Your ref:	22 Hyde Park Gardens	Please reply to:	Fraser Fikrie
Our ref:	24/00319/LBC	Tel No:	0753424 7967
		Fee Queries:	0207 641 6500;
		Email:	planningreception@westminster.gov.uk;
Mr Padraic Lucas Anstey Horne & Co Ltd 4 Chiswell St, London EC1Y 4UP United Kingdom		Incomplete Applications Town Planning & Building Control City of Westminster PO Box 732 Redhill, RH1 9FL	
		24 January 2024

Address: Centre Basement Flat, 18-21 Hyde Park Gardens, London, W2 2LY,

Proposal: Redecoration works to the external walls and boundaries with associated render and brickwork repairs, roof replacement, repairs of the rainwater discharge system to the north elevation.

<b>DRAWING No:</b> BSC1073_101_02	<b>REVISION:</b> 02
--------------------------------------	------------------------

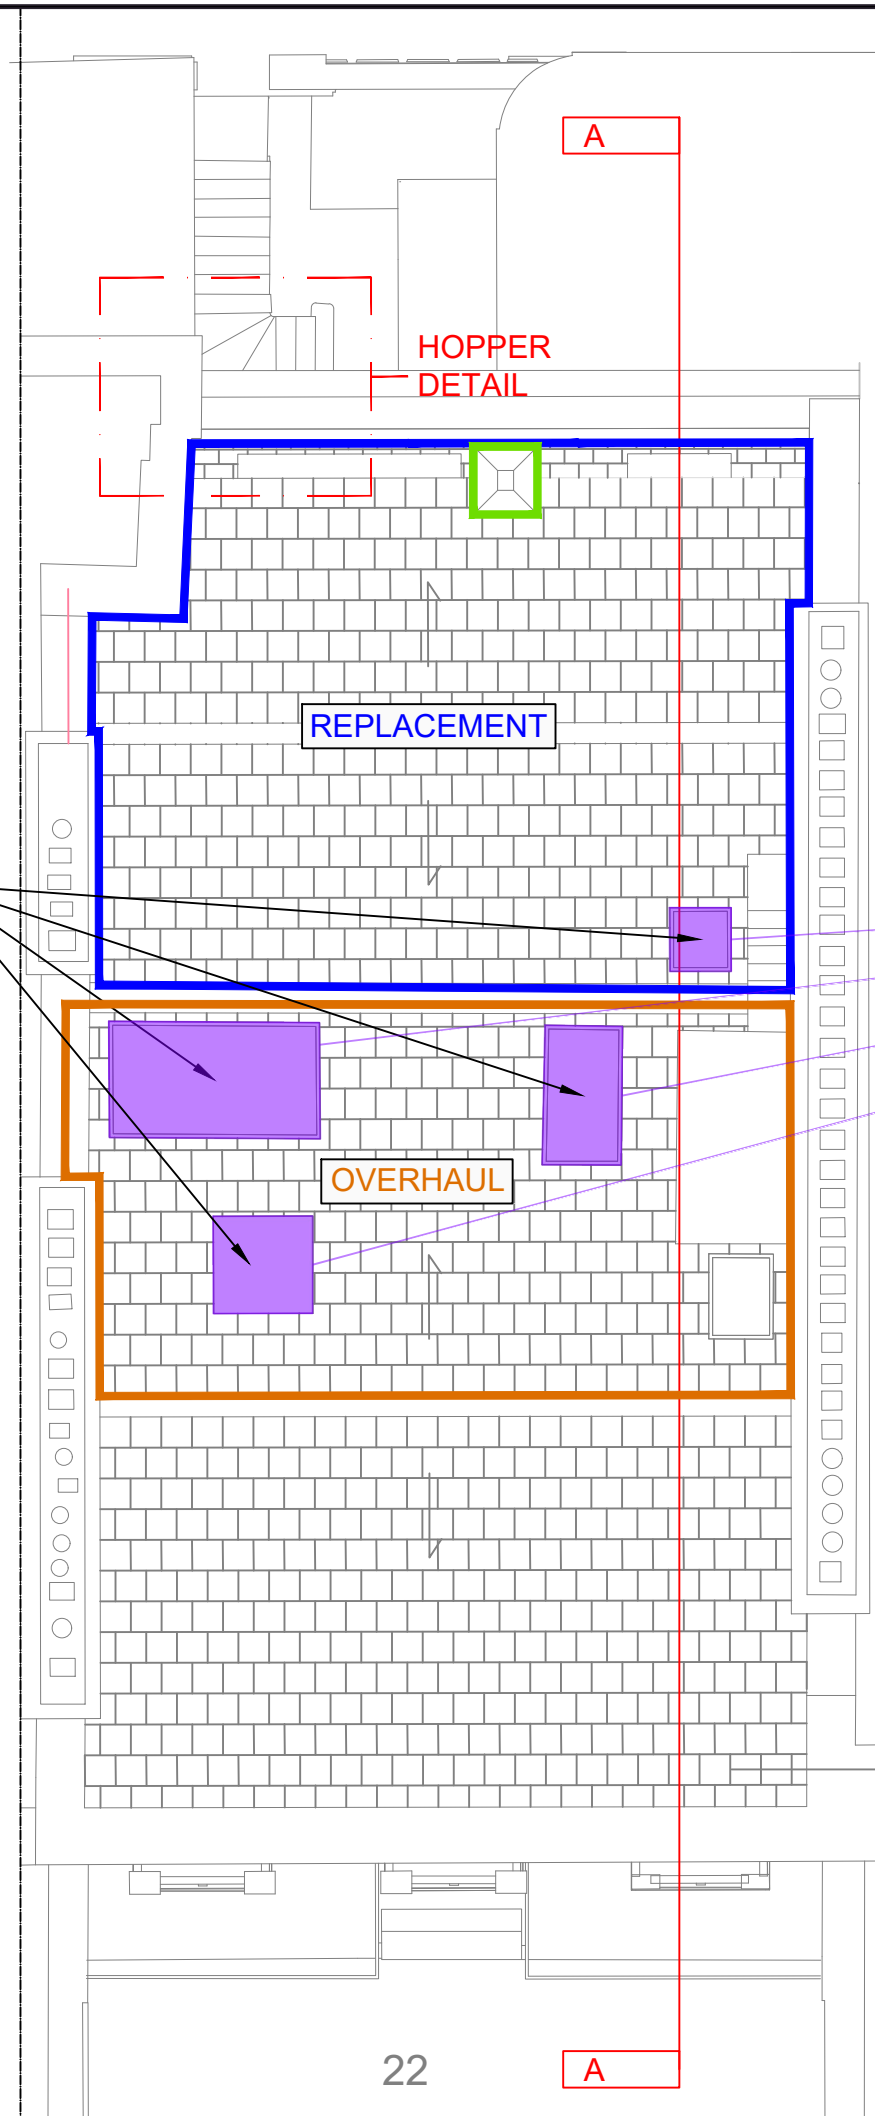
- 2 - Rear elevation is un-readable and unclear as the drawings are faint. Need to be the same level of clarity as other elevation drawings
 - The roof plan includes a number of annotations in relation to PV panels, chimneys cowl, rooflights - all of which require further details and need to be included in the description of development on the application form
 - The proposed front elevation drawing does not appear to show the hopper detail as shown on drawing: 'BSC1073_100_05'
